Appendix A Response to Issues

Issue/comment	Response
Department of Planning	
Urban Design and Subdivision Layout	
The number of lots proposed on this environmentally sensitive site is considered to be excessive and would create a dense residential population in an otherwise rural residential setting. It is recommended that the total number of lots be reduced, particularly on the eastern part of the site to allow the development to better integrate with the surrounding locality. This would allow for a reduced number of lots, and dwellings to be setback further from the edge of the subdivision to facilitate a better aesthetic transition to the rural residential area that is directly adjacent to the eastern part of the site. This would also help to minimise the impacts of residential development on environmentally sensitive areas.	Section 3.2.1
The Landscape Plan shows a bush pathway and boardwalk within an area defined as SEPP 14 Coastal Wetlands. This area of the site is considered to be of high ecological value and its protection is imperative. In order to prevent degradation and irreversible damage to the wetland, and to avoid an increased human traffic in this location, the prop

LEGEND

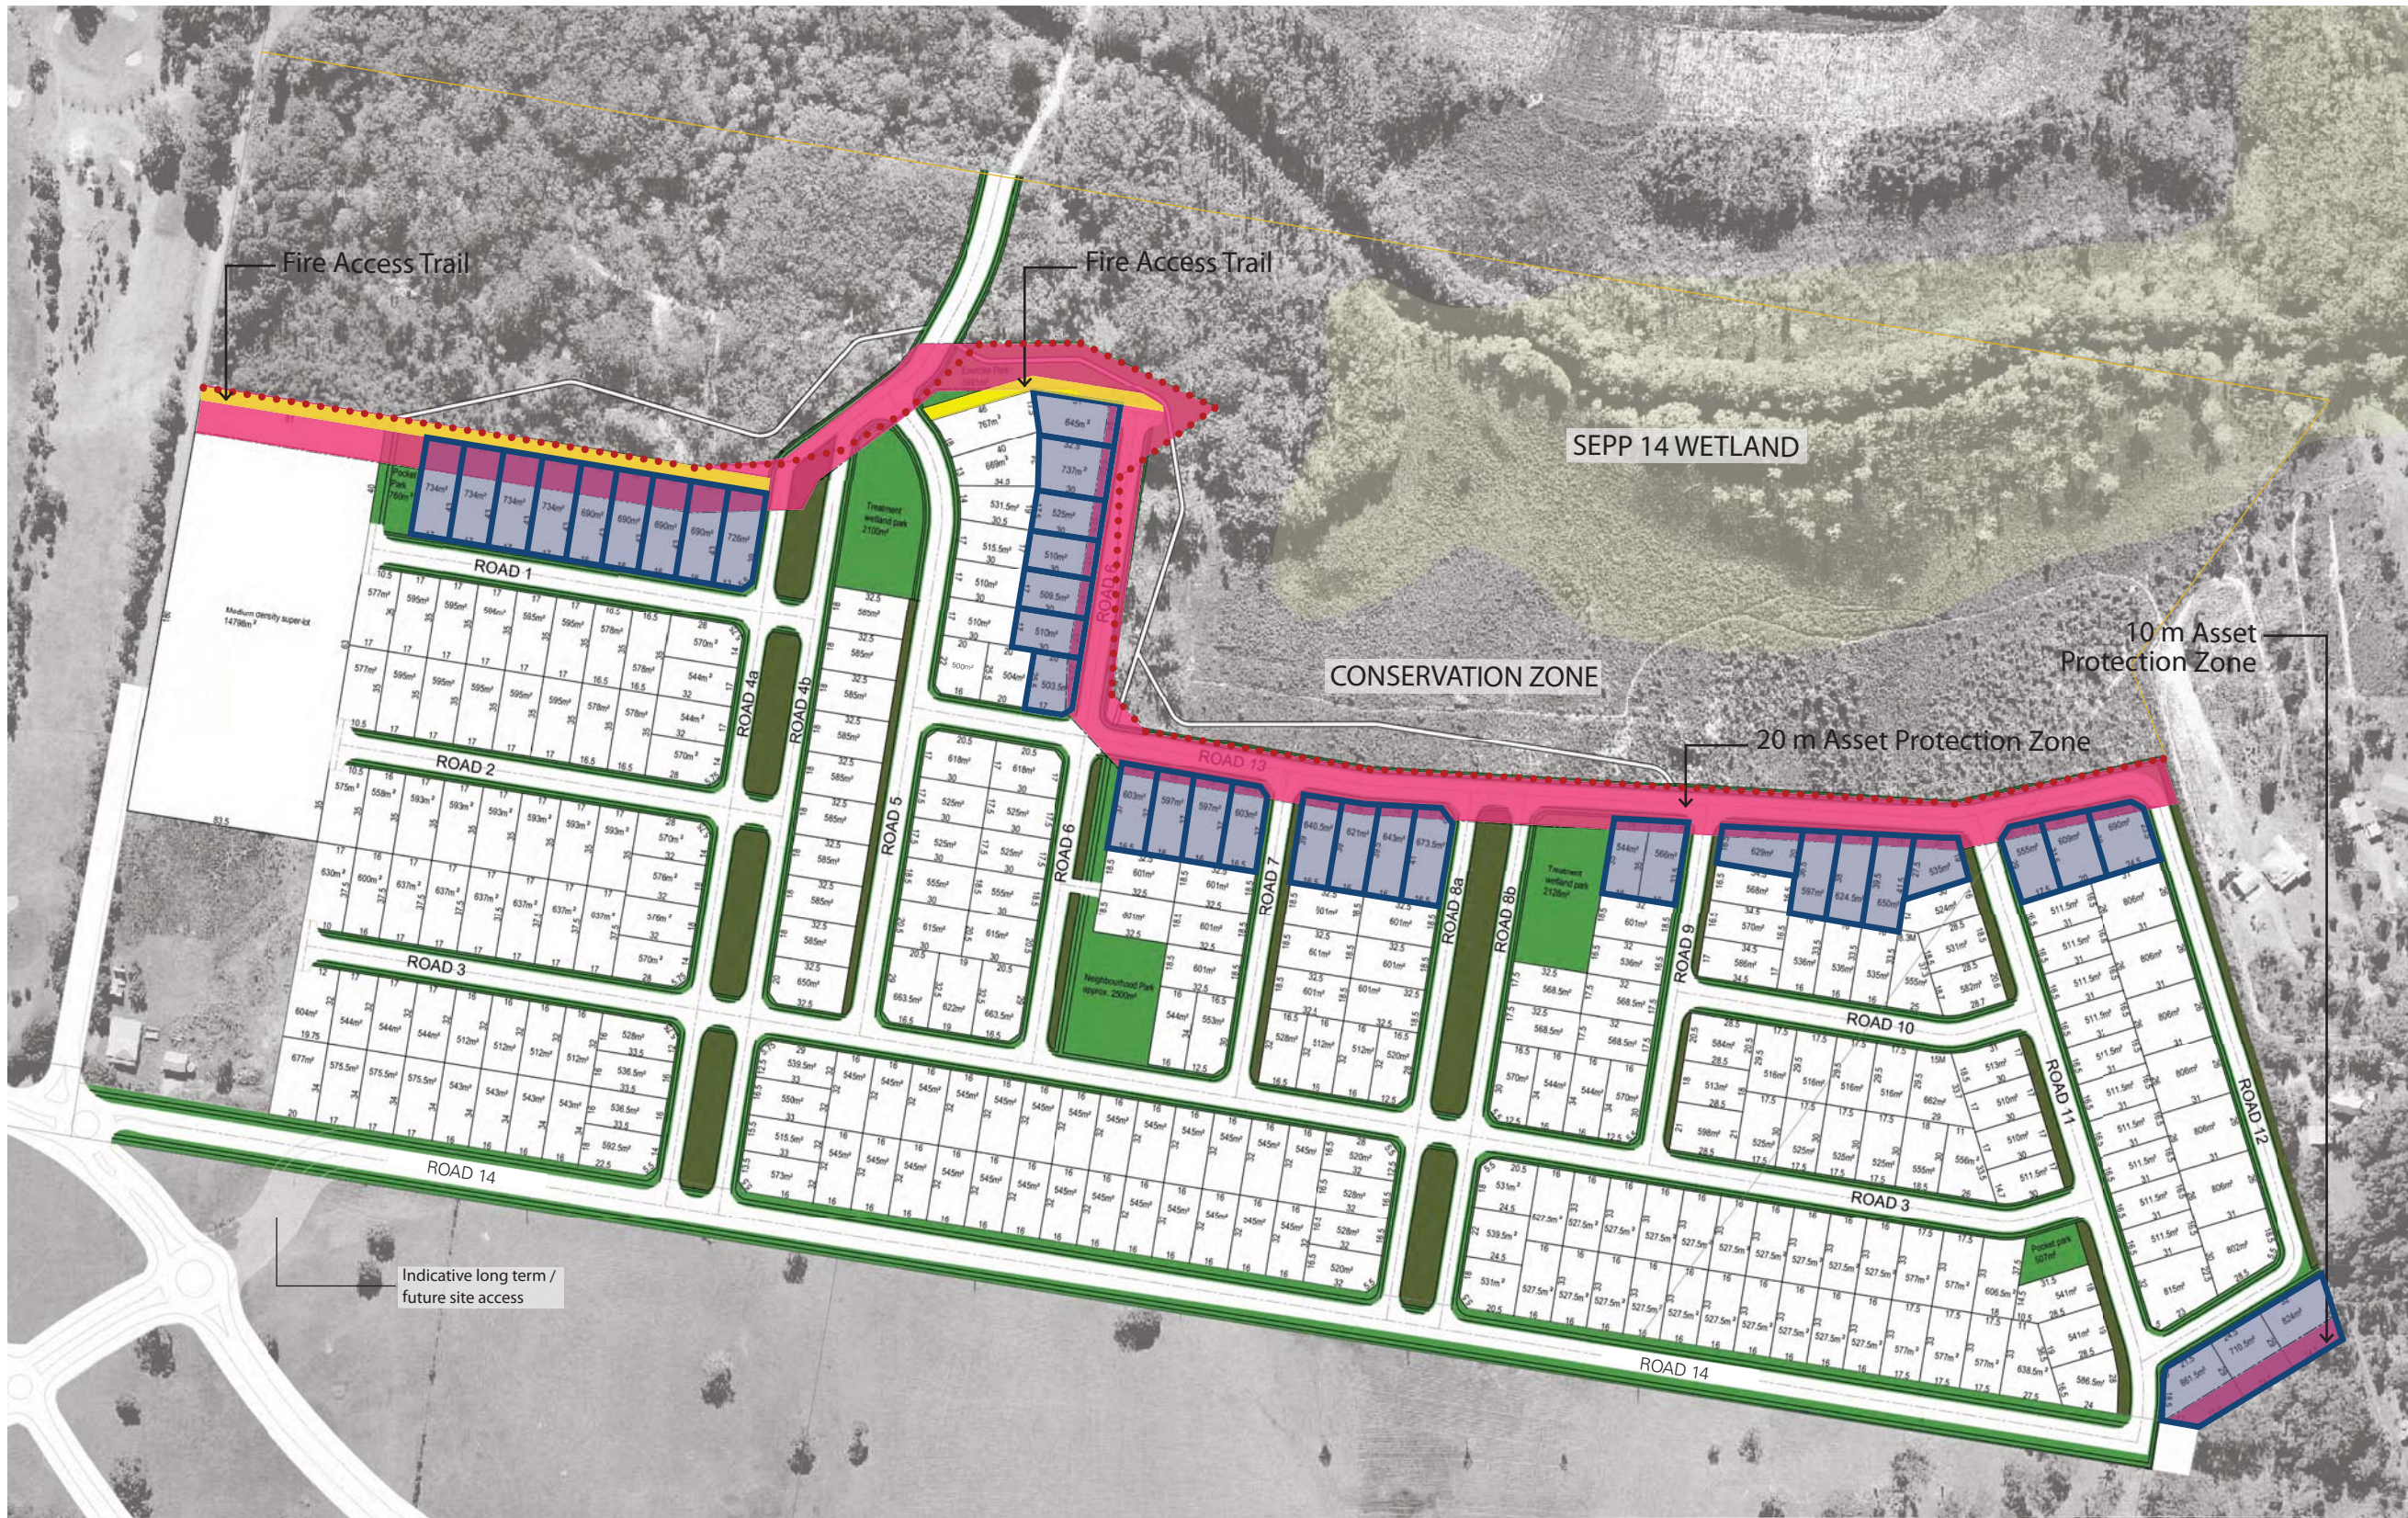
Issue/comment	Response
Rural Fire Service	
At the issue of subdivision certificate and in perpetuity a 20m APZ is to be provided to the northern elevation of the development zone and shall be managed as an inner protection area (IPA) as outlined within Section 4.1.3 and Appendix 5 of <i>Planning for Bush Fire Protection (PBP) 2006</i> and the NSW Rural Fire Services document Standards for asset protection zones.	Section 3.8
A 10m APZ to be provided from the south-eastern boundary of proposed Lots 315, 316, 317 and 318 of the development. In accordance with Section 88B of the Conveyance Act 1919 a restriction to the land shall be placed on these lots requiring the provision of this APZ which shall be maintained as outlined within Section 4.1.3 and Appendix 5 of PBP 2006 and the NSW Rural Fire Services document Standards for asset protection zones. This restriction can be extinguished upon commencement of any future proposed residential development on the adjacent lot, but only if the hazard is removed as part of the proposal.	Section 3.8

The entire development precinct shall be as a minimum managed as an outer protection zone until the completion of the subdivision. Each stage shall be provided to those edges that do not require permanent asset protection zones, a temporary 100m wide inner protection zone.	Section 3.8
At the issue of the subdivision certificate and in perpetuity, the land surrounding the existing dwelling to a distance of 20m shall be maintained as an IPA as outlined in Section 4.1.3 and Appendix 5 of PBP 2006 and the NSW Rural Fire Services document Standards for asset protection zones. This restriction can be extinguished upon commencement of any future proposed residential development on the adjacent lot, but only if the hazard is removed as part of the proposal.	Section 3.8
Water electricity and gas must comply with section 4.1.3 of PBP 2006.	Section 3.8
Road Access should comply with section 4.1.3(1) of PBP 2006.	Section 3.8
